Rezoning Transportation Analysis

Petition Number: #2022-125

Date	Description
12-29-22	First Review (TM)

PROJECT:
TENNYSON
TOWNHOMES
TENNYSON DR.
Charlotte, NC

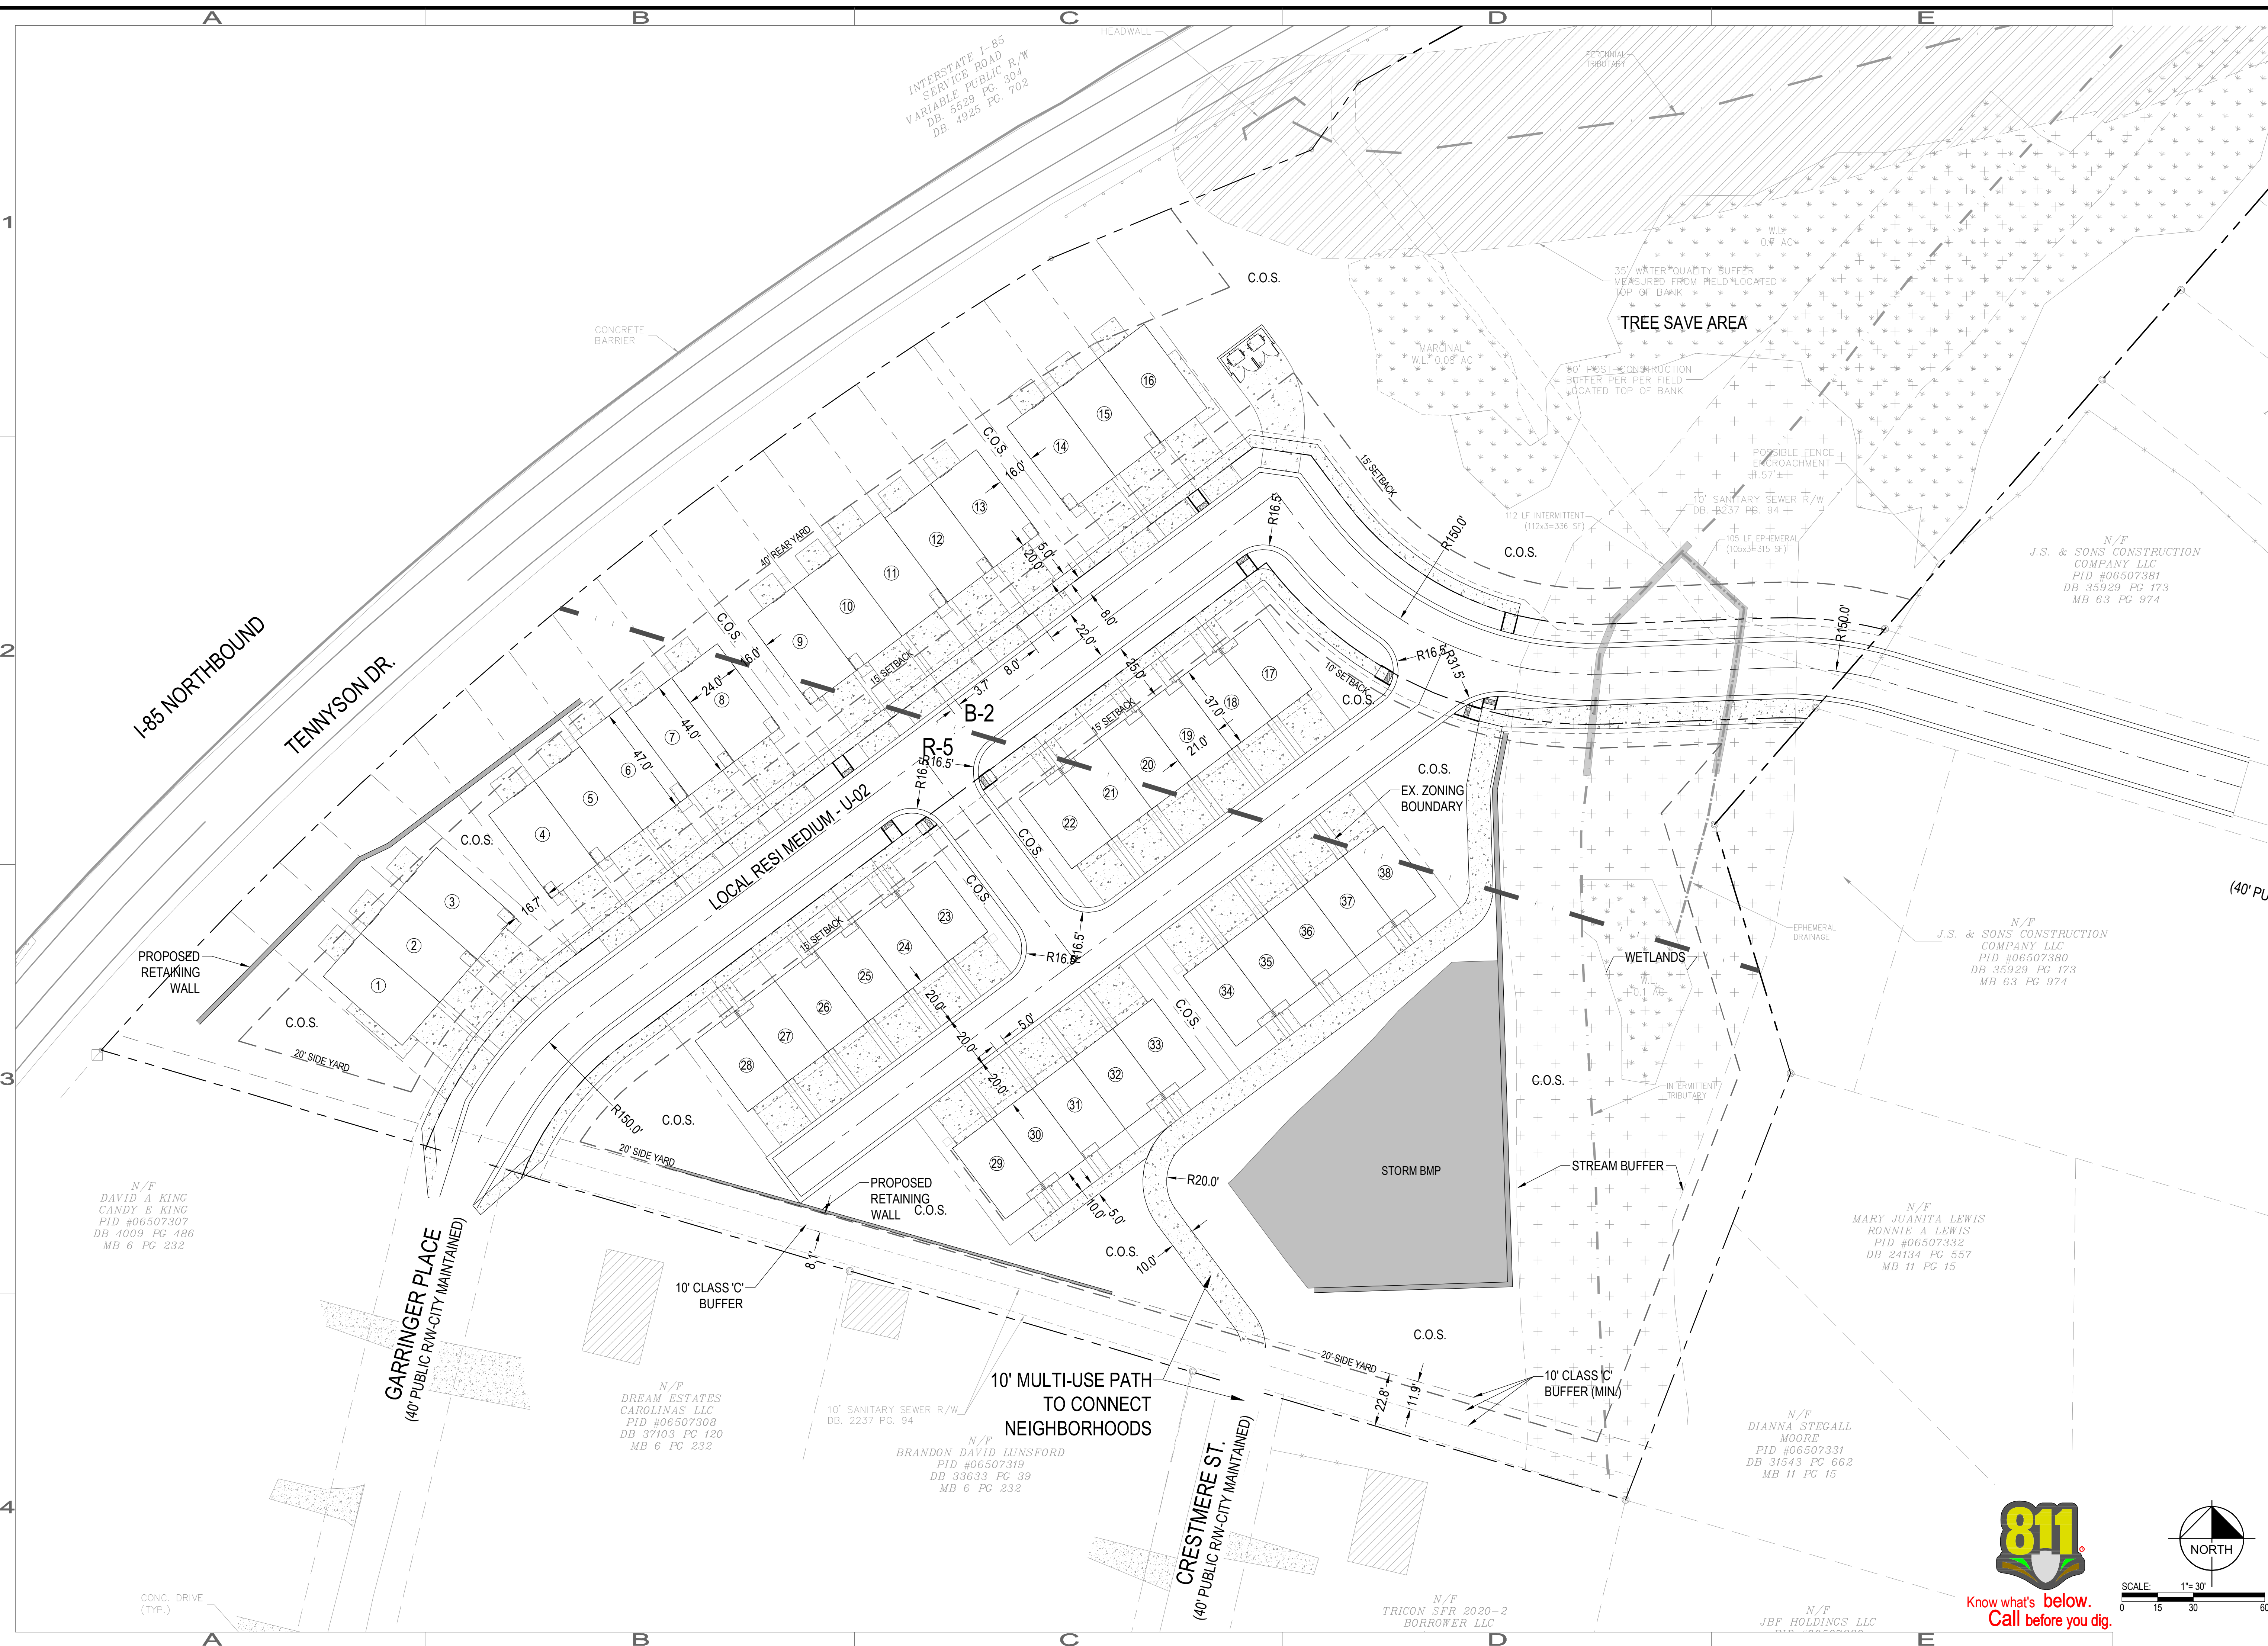
Label and dimension the curb and gutter from the centerline for each road on the site plan.

- 3. Revise site plan and conditional note(s) to commit to dedicate a min of 28-feet of right-of-way from the road centerline along site frontage of Tennyson Drive. The site plan shall label and dimension the right-of-way from the road centerline.

- 4. Revise site plan and conditional note(s) to commit to construct an 8-foot planting strip, and 6-foot sidewalk on all internal public roadways per Chapter 19. The site plan shall label and dimension both items from the back of curb and gutter or edge of pavement.

- 6. Revise site plan and conditional note(s) to meet CDOT standards for public roadway geometry. Label each roadway as public or private.

7. Revise site plan and conditional notes(s) by changing the 10-foot Multi-use path to a 12-foot multi-use path.
